Addendum No. 2

RE: Contract ID C203185
WBS # 45530.3.1
F. A. # FBD-0306(8)
Craven County (F-5500)
NC-306 At Cherry Branch Ferry

The following revision has been made to the Structure Plans:

REVISIONS						SHEET NO.
NO.	BY:	DATE:	NO.	BY:	DATE:	S-28
1			3			TOTAL SHEETS
2			4			29

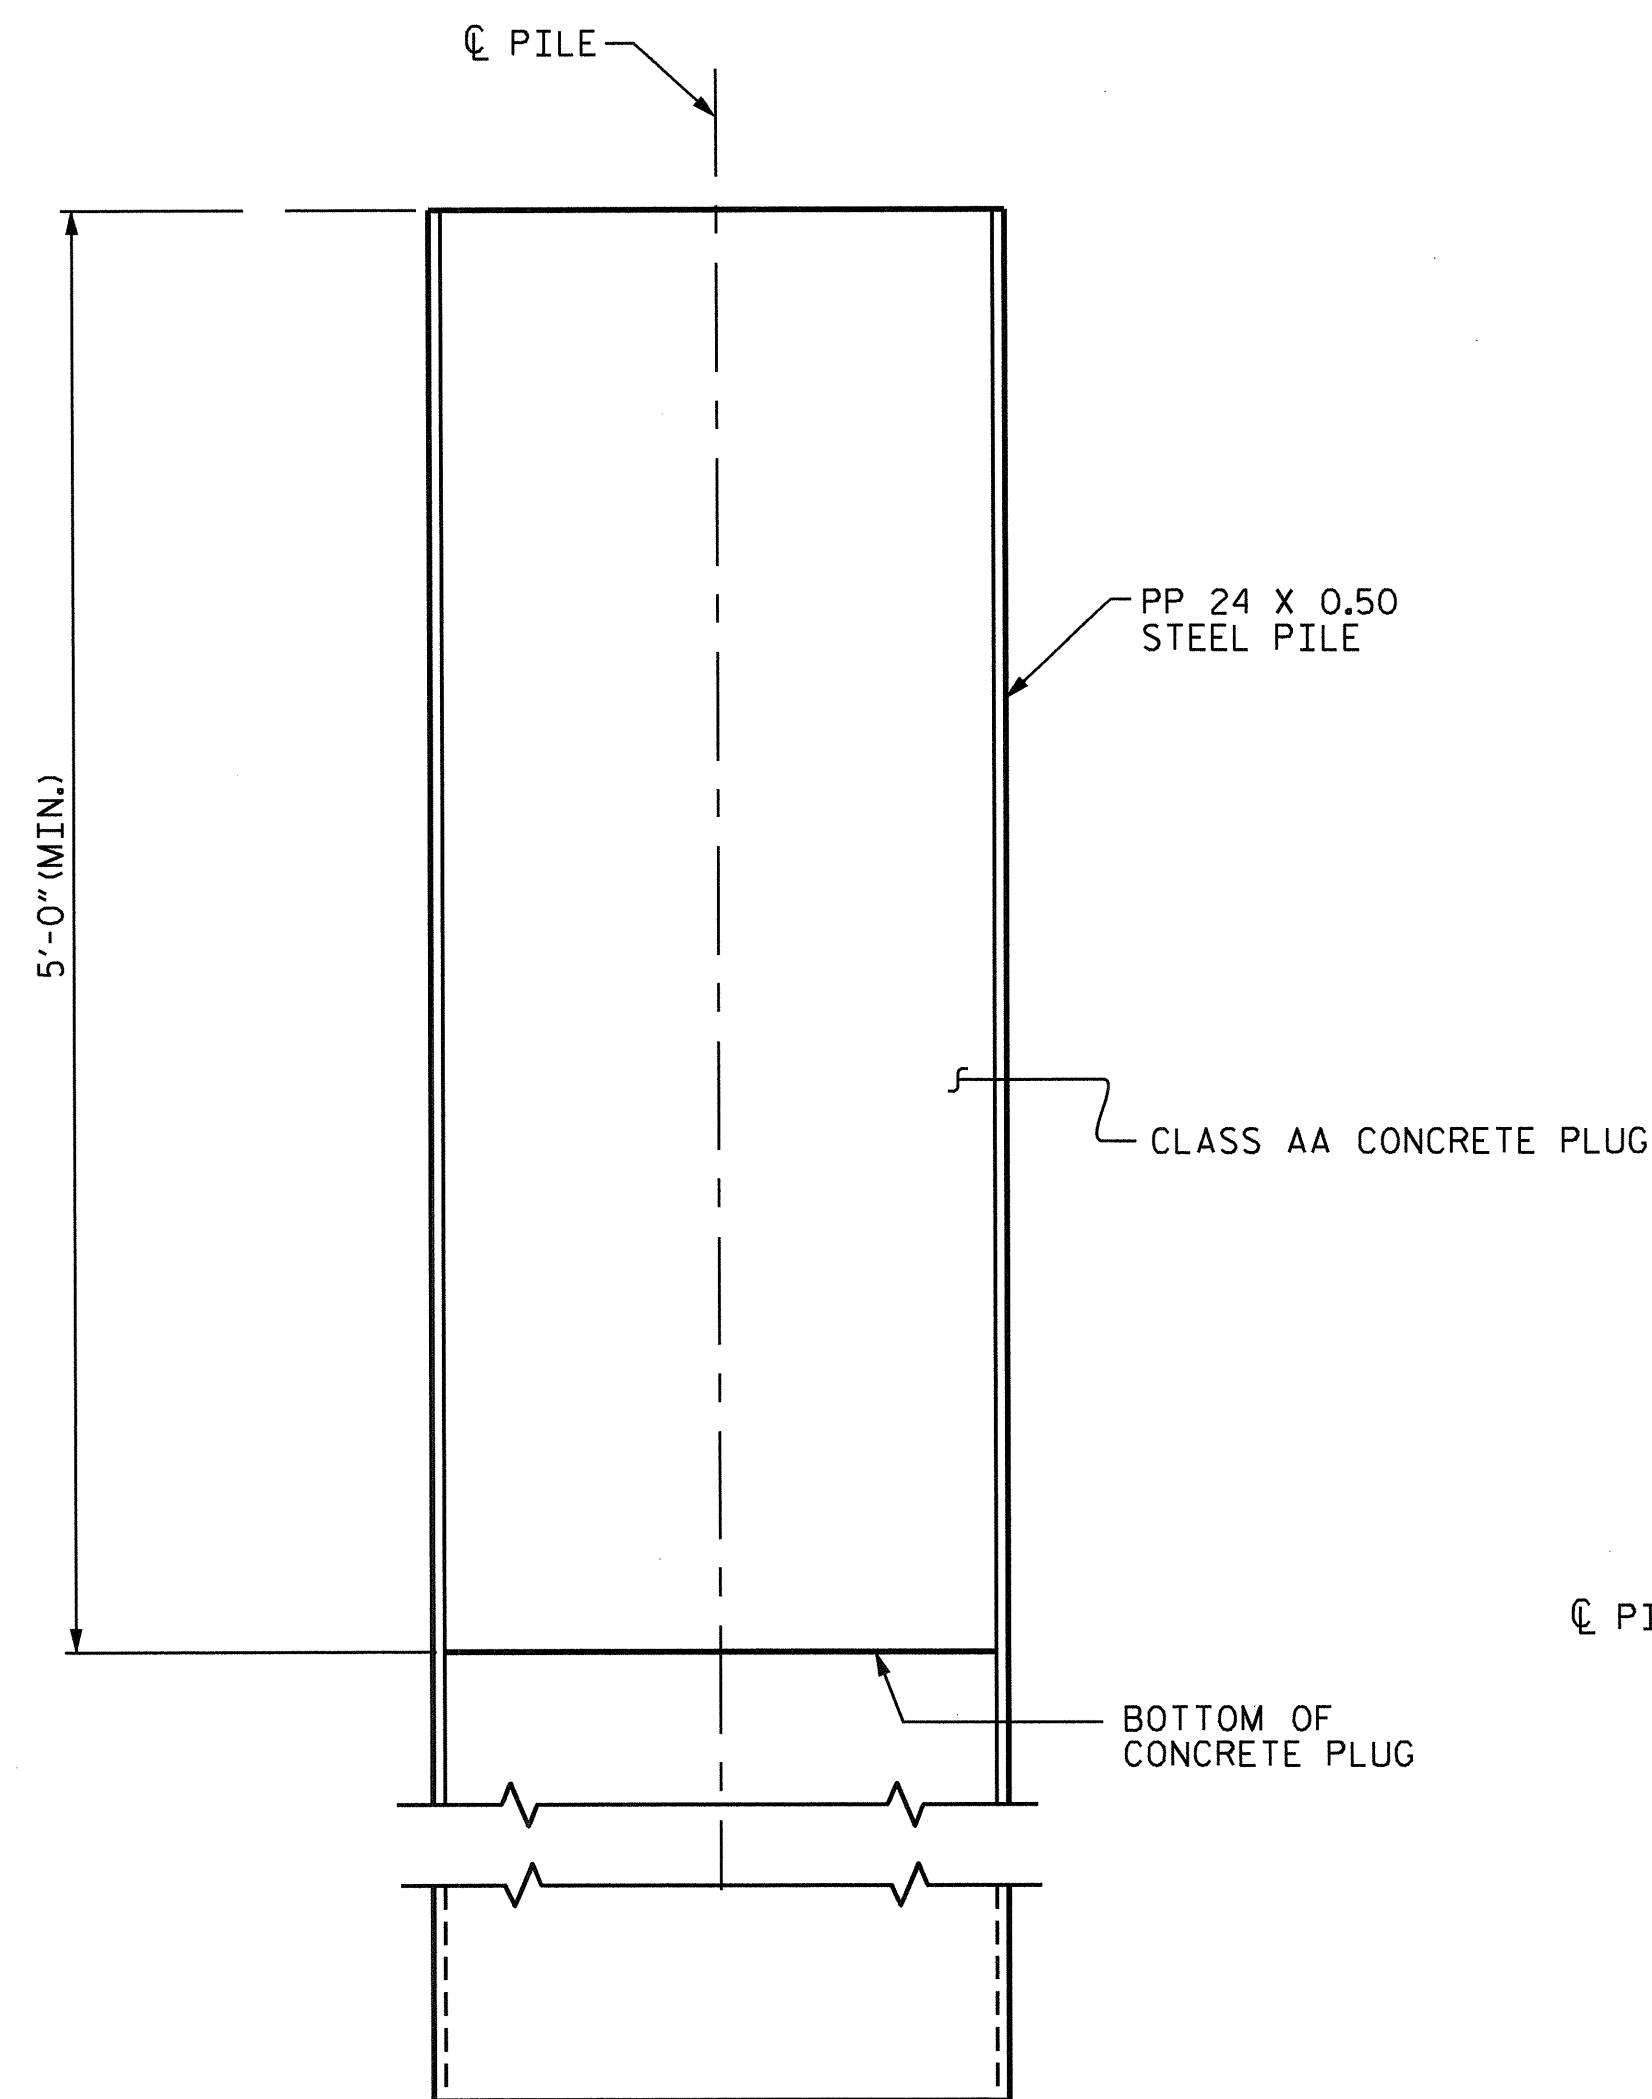
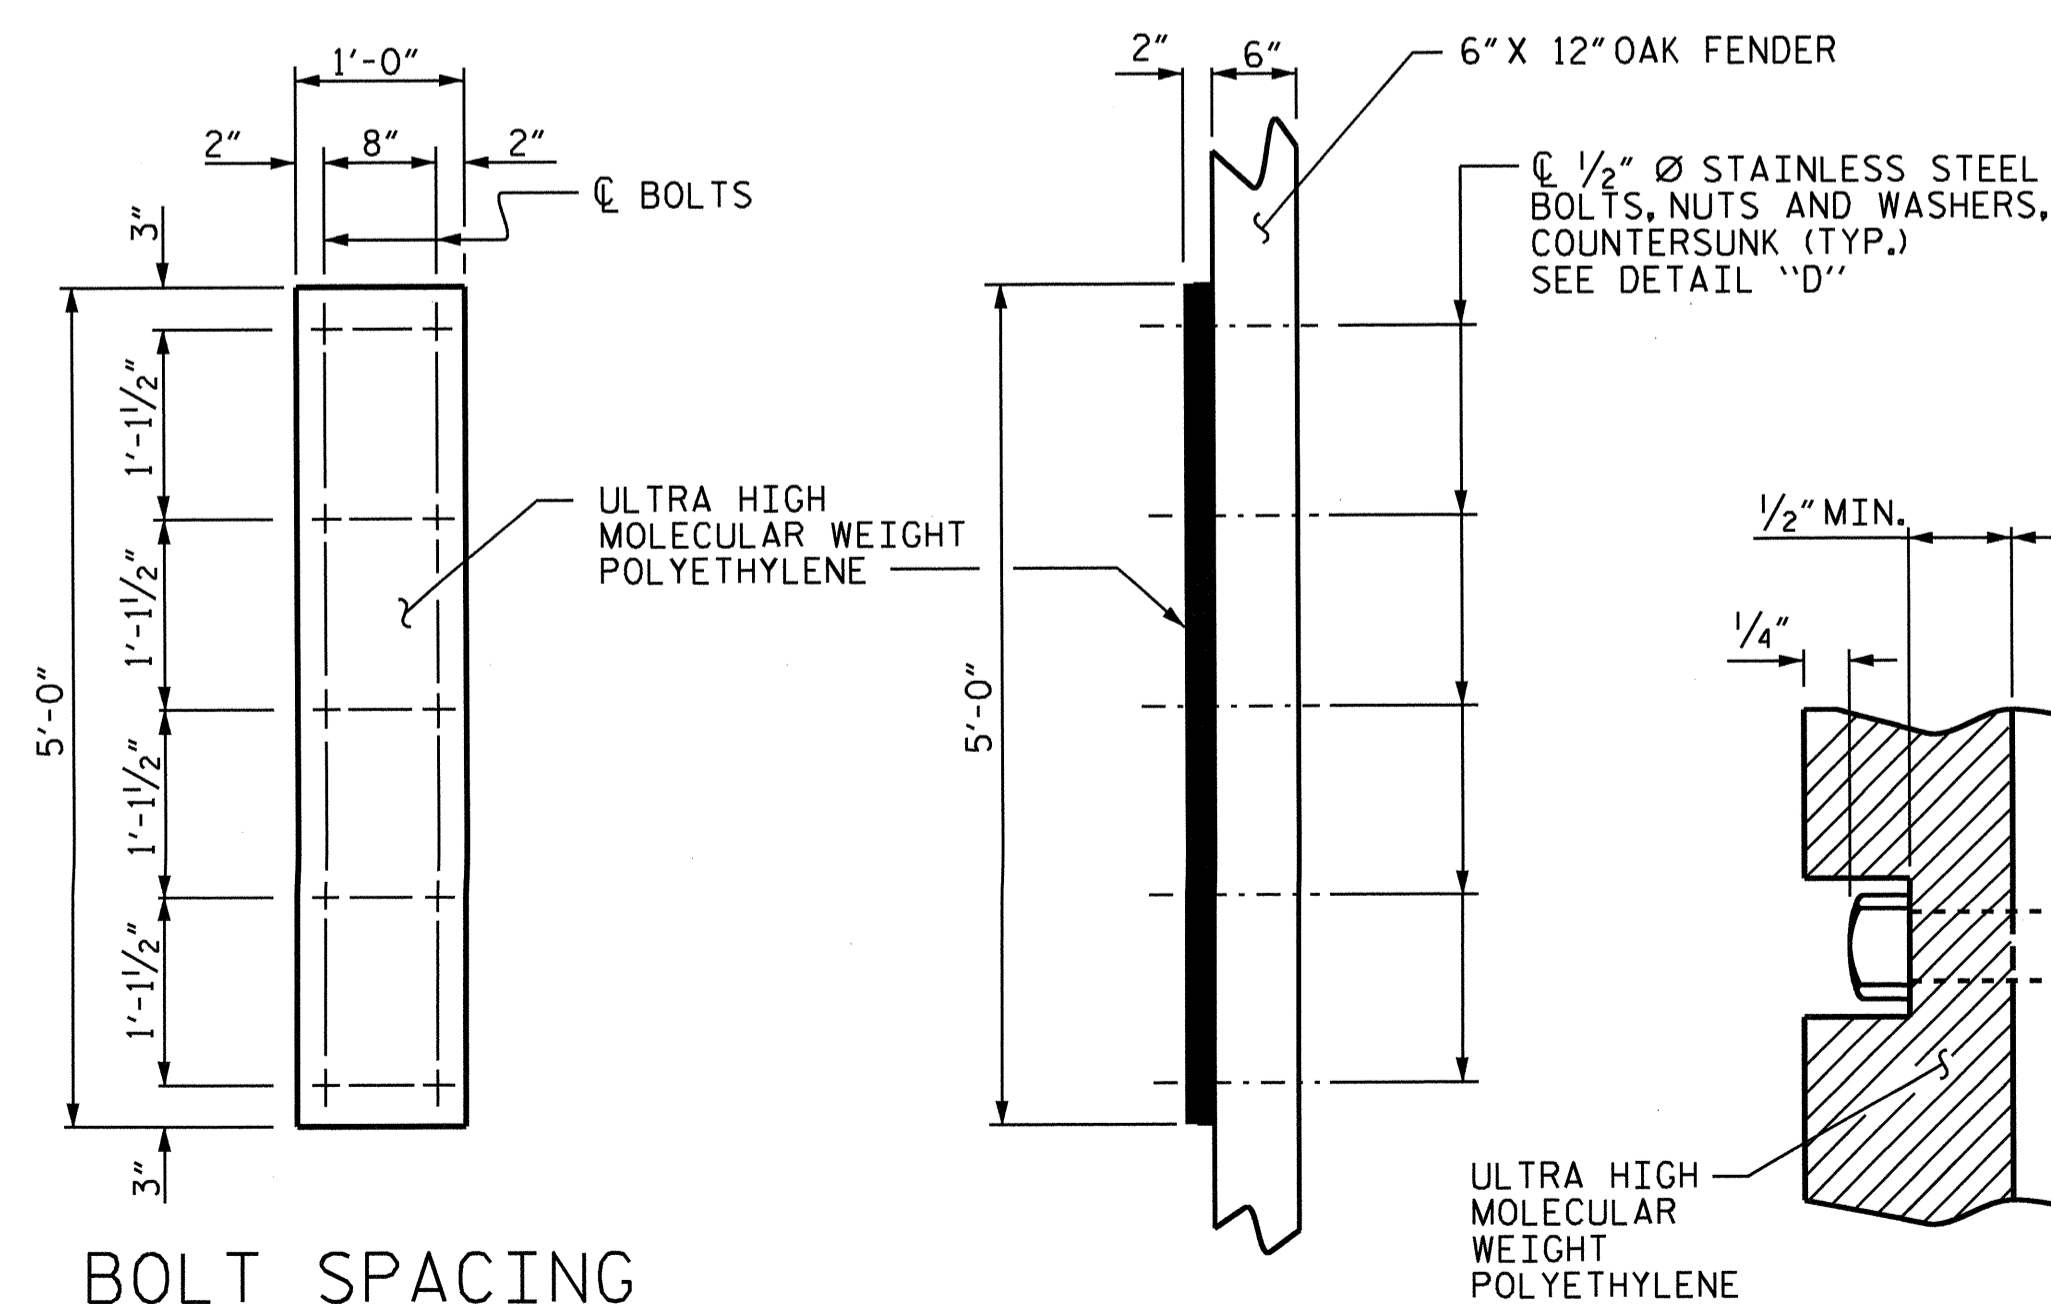
On Sheet No. S-28 in the Bill Of Material the notation for 2% copper in the 24" Diameter Steel Pipe Piles has been removed. Please void Sheet No. S-28 in your plans and staple the revised Sheet No. S-28 thereto.
